Ribble Valley Borough Council
Housing & Development Control

Application no: **3/2021/0793**

Address: **Coars Farm Garden Centre Settle Road Bolton By Bowland BD23 4SN**

The Local Highway Authority have viewed the plans and highway related documents and have the following comments to make:

These are shown below.

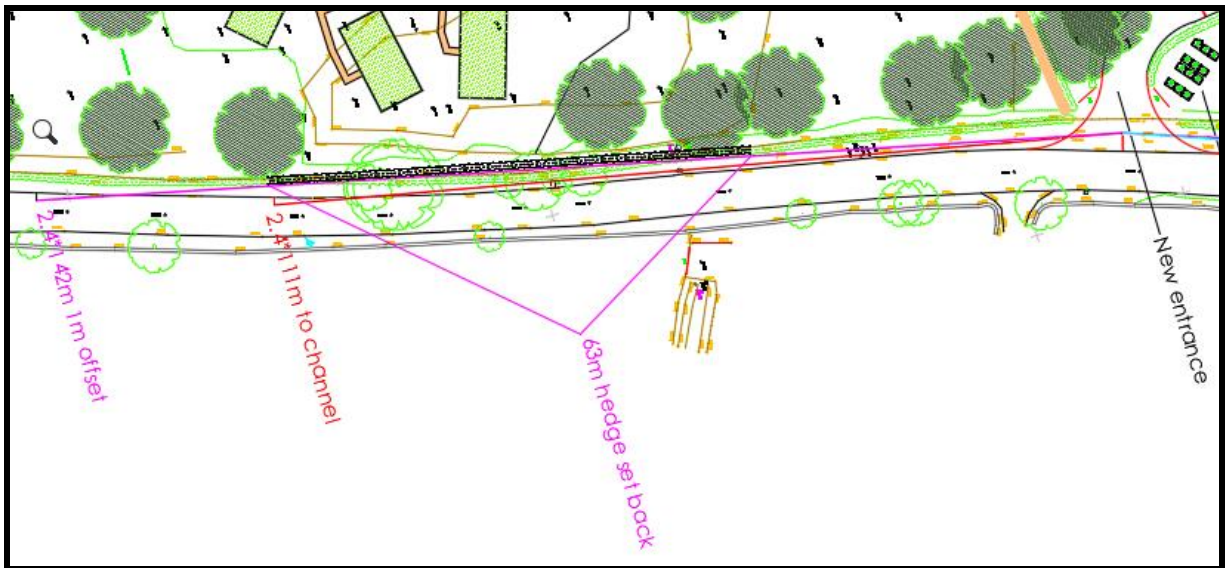
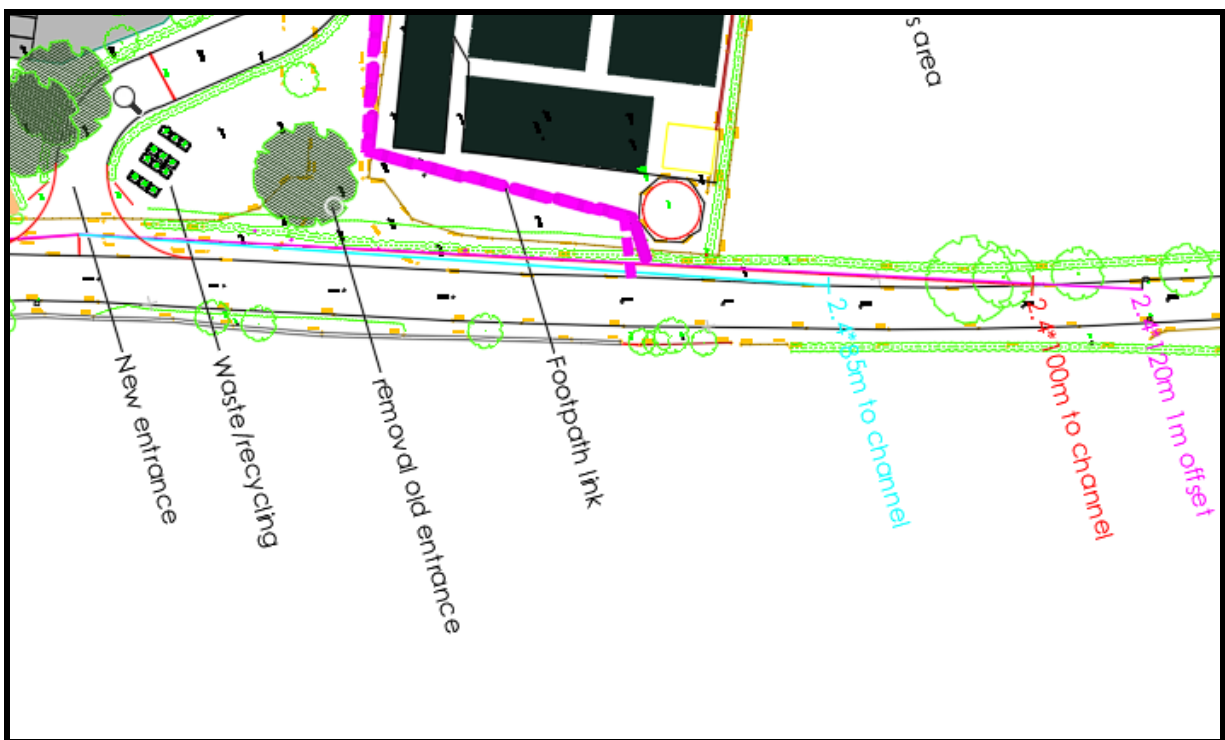
In the Transport Statement (p22), the Transport Consultant has provided a visibility splay drawing showing the access can provide the minimum visibility as expressed above in both directions. However, the LHA are unable to accept the drawing because it is not scaled and so the LHA are unable to fully review the drawing. As a result, the LHA require a revised scaled access drawing showing the visibility splays in both directions.

Not only this but the LHA are unable to accept the speed survey data which was conducted between 17th September to 23rd September 2020. This is because the data was collected at a time where traffic counts remained lower than historic levels due to the Covid 19 pandemic. As a result, the LHA are not accepting any traffic counts which have been undertaken during this period and so request the Agent to undertake another speed survey to support the application.

Instead of the data being collected for a week like previously, the LHA will accept a day of data collection which will allow for the LHA to compare both sets of data. This way the LHA are likely to accept the shortfall in visibility for a 60mph road which is required to provide minimum visibility splays of 2.4m x 215m in both directions.

Subsequently, the Applicant could provide a scaled visibility drawing showing the access can provide the full minimum visibility splays for a 60mph road. If this is the case, the minimum visibility should be shown on a revised scaled drawing.
